Subject: METROWEST DCO EXAMINATION – ISSUE SPECIFIC HEARING 3 (ENVIRONMENTAL MATTERS) – ENVIRONMENT AGENCY WRITTEN RESPONSE TO AGENDA ITEM 5 (FLOOD RISK, DRAINAGE AND CONTAMINATED WATERS)

Our ref: WX/2019/133441/01-L09
Your ref: TRO40011
Date: 10 January 2021

**METROWEST DCO EXAMINATION – ISSUE SPECIFIC HEARING 3
(ENVIRONMENTAL MATTERS) – ENVIRONMENT AGENCY WRITTEN RESPONSE
TO AGENDA ITEM 5 (FLOOD RISK, DRAINAGE AND CONTAMINATED WATERS)**

## Functional Floodplain

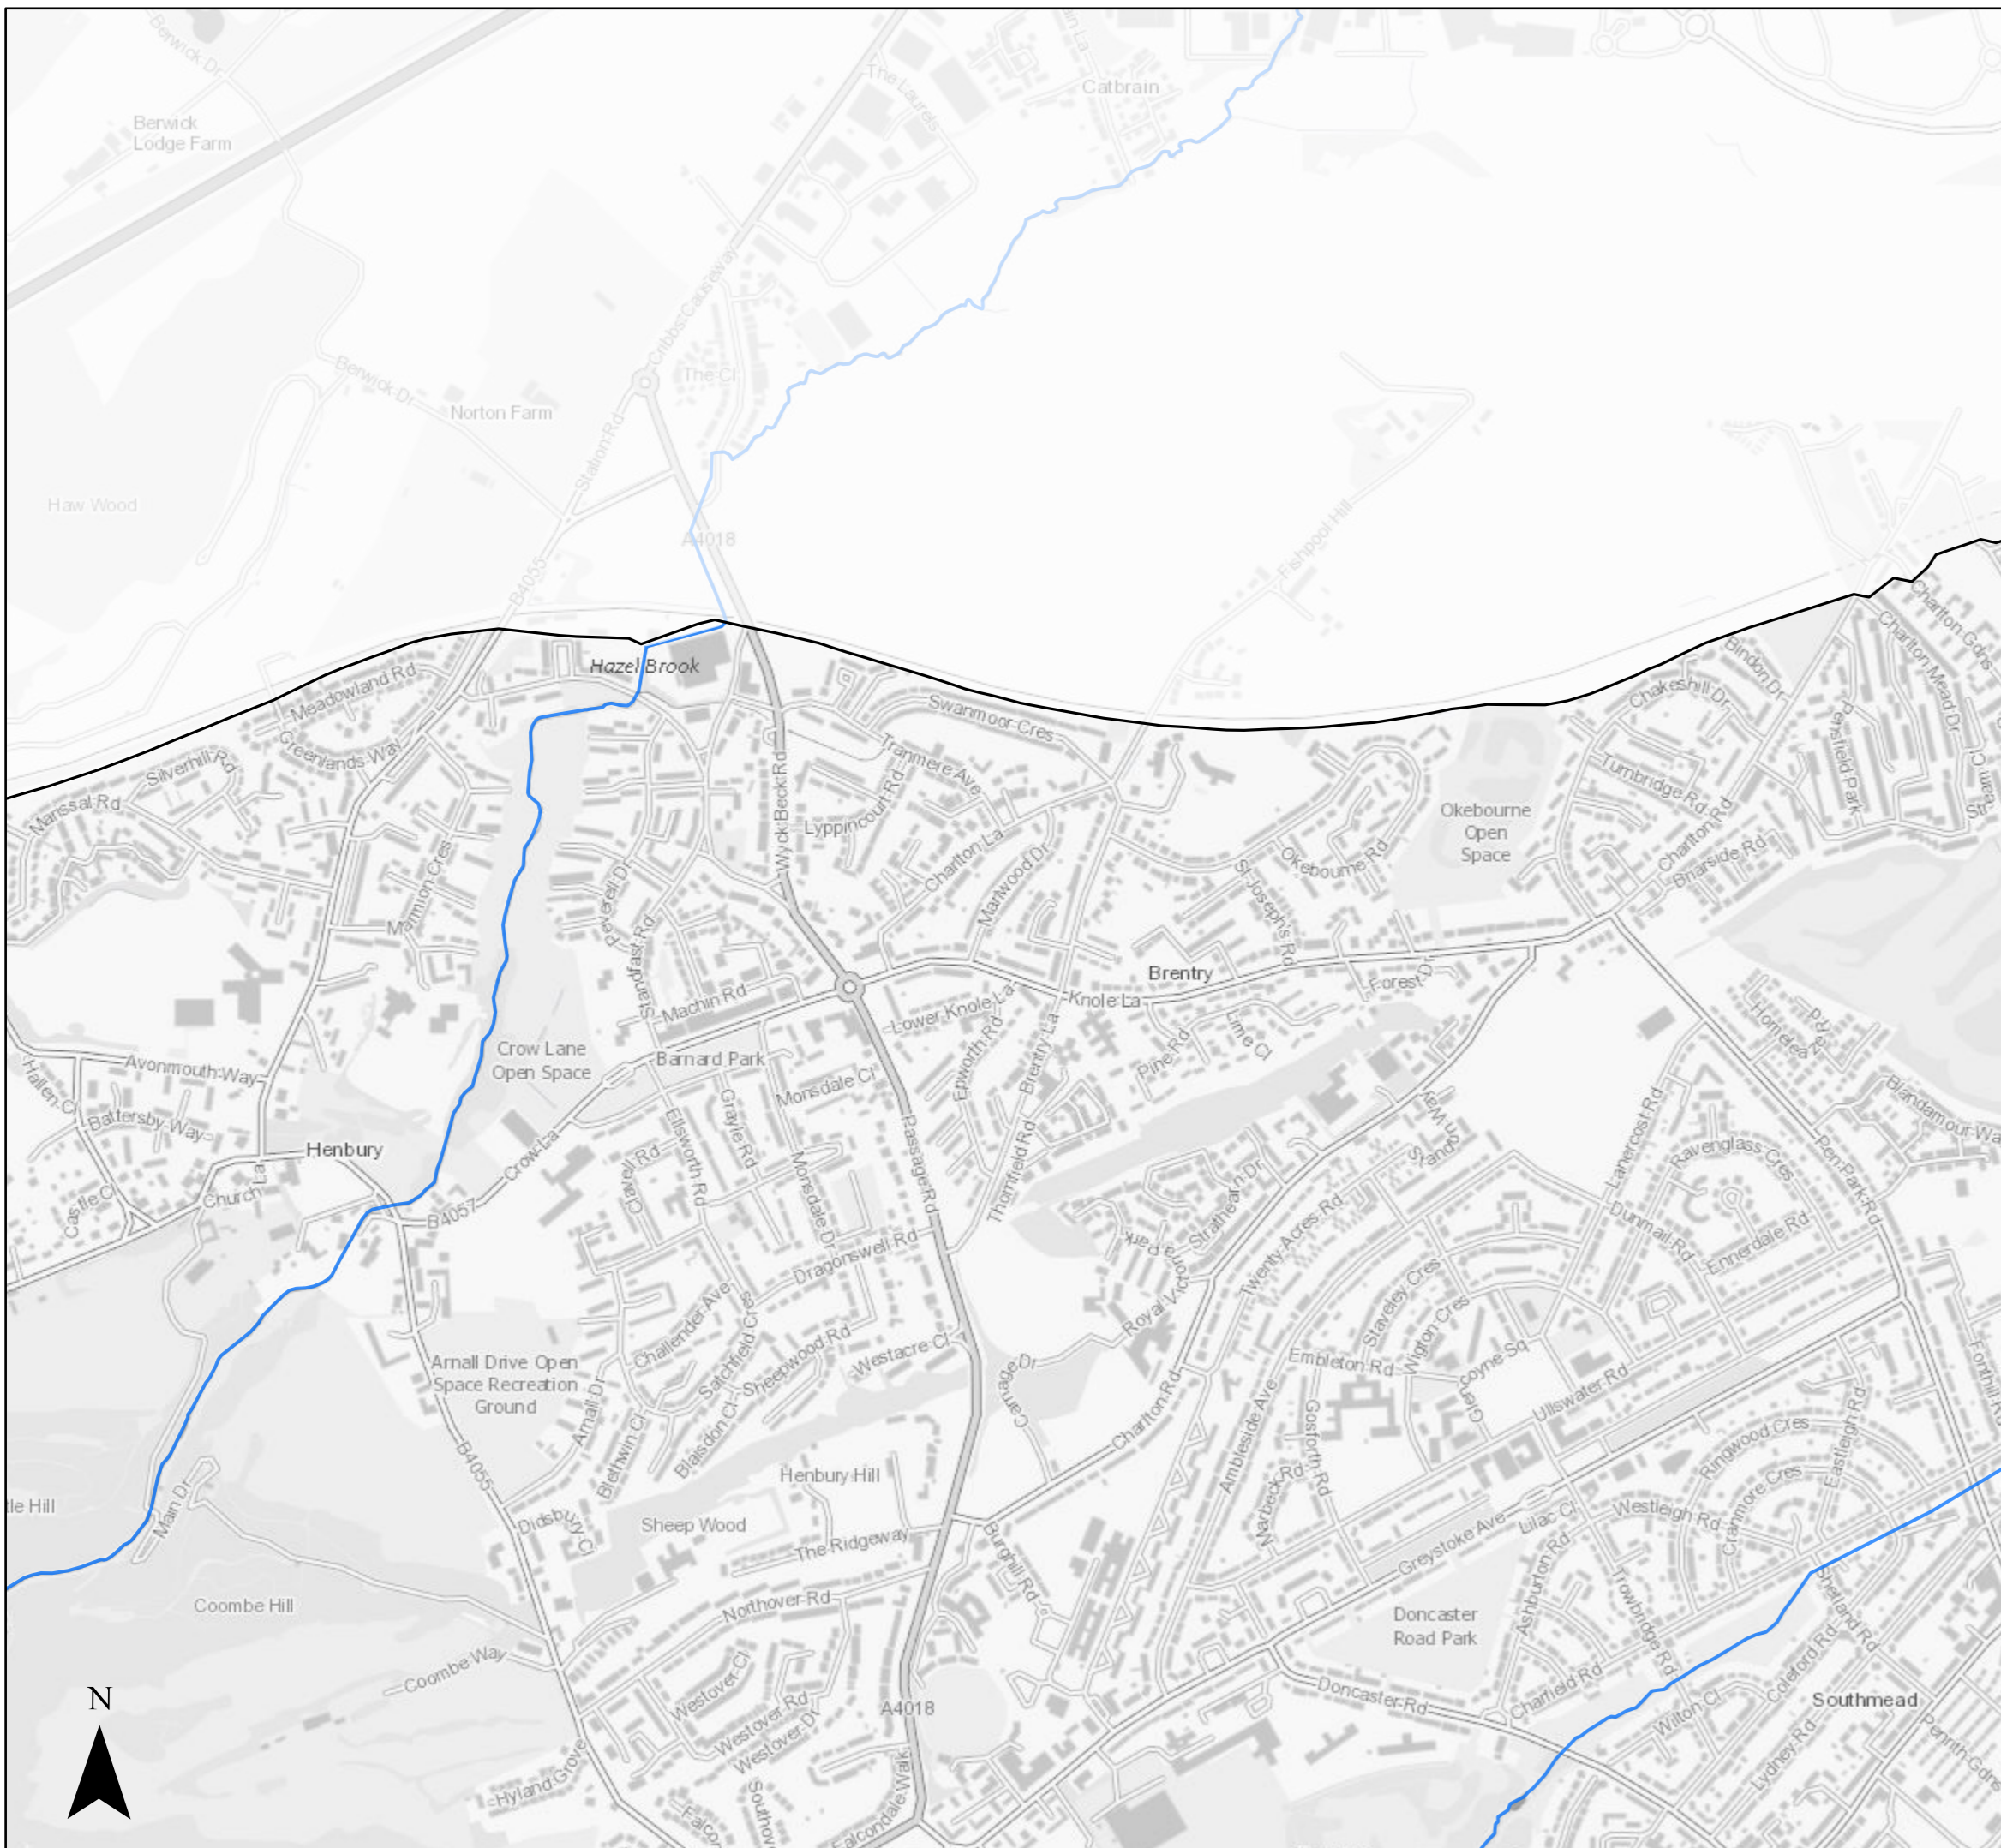
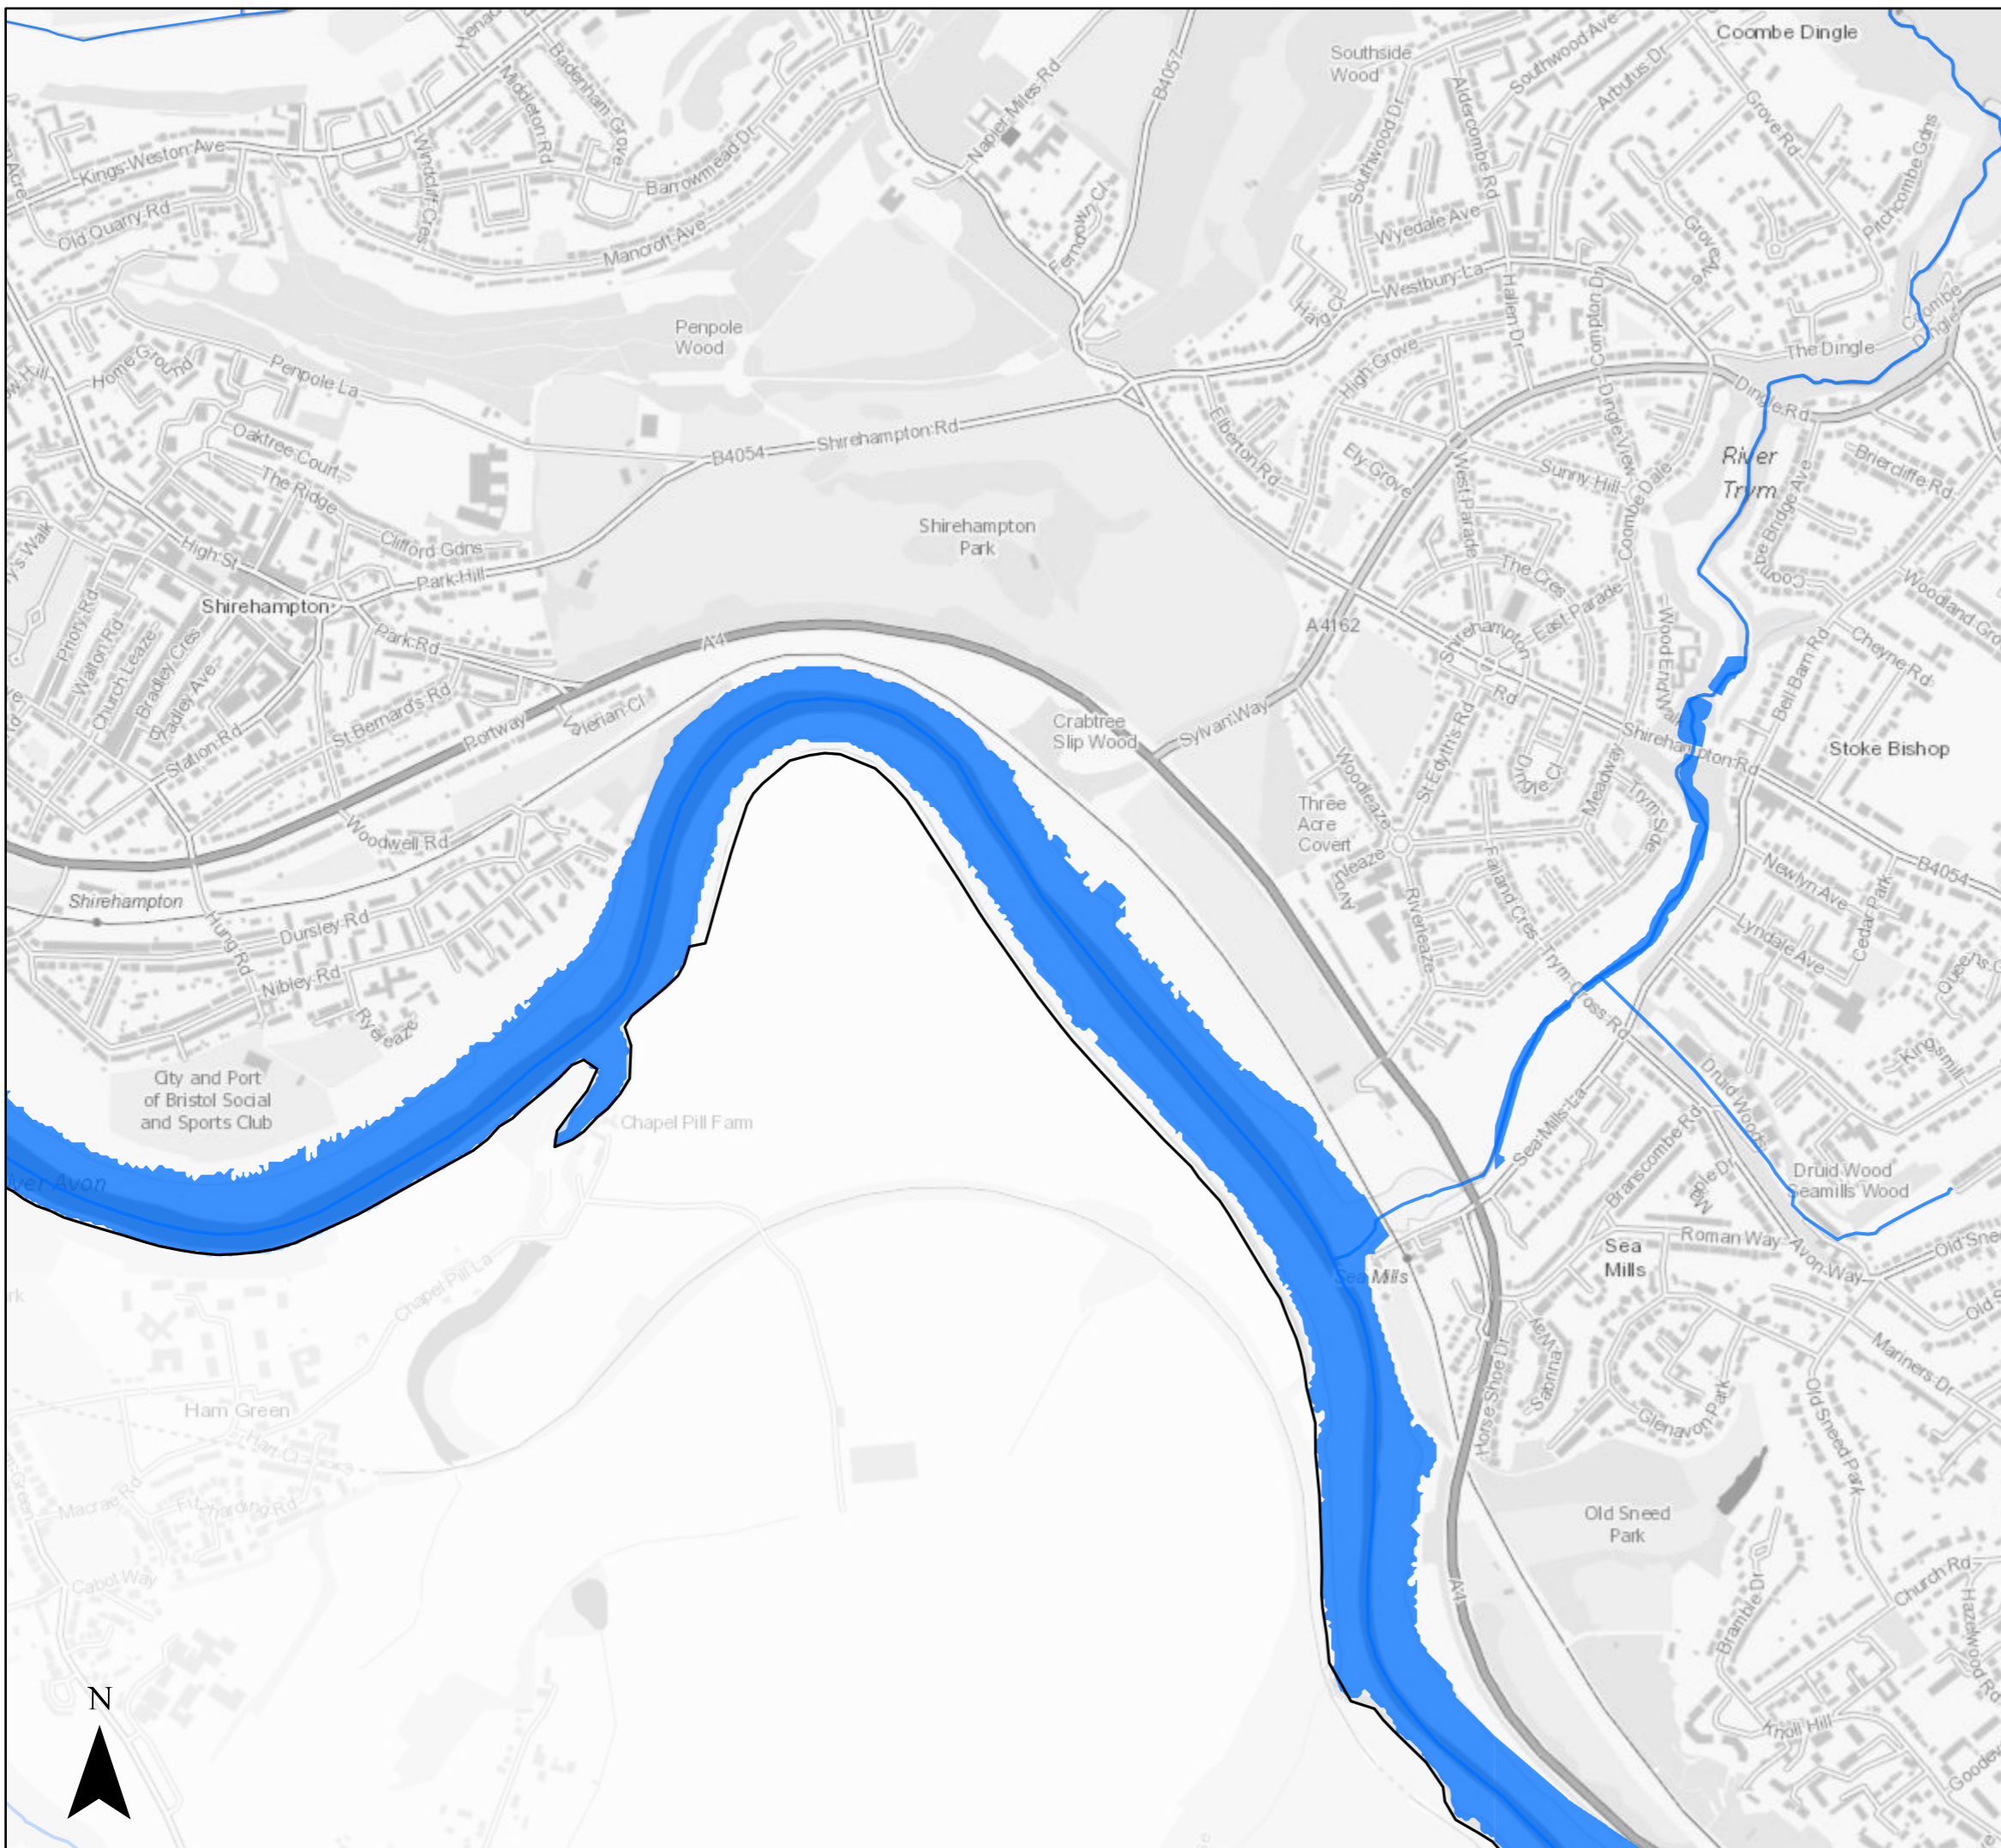
The applicant's representatives have recently cited the updated Bristol Strategic Flood Risk Assessment as evidence that no part of the application area is located within Flood Zone 3b (functional floodplain). This is obviously at variance with the applicant's own site specific flood risk model, which should be considered a more detailed assessment of the actual flood risk. Accordingly, the Agency must advise that parts of the application area are within Flood Zone 3b (functional floodplain), as detailed in the applicant's Flood Risk Assessment.
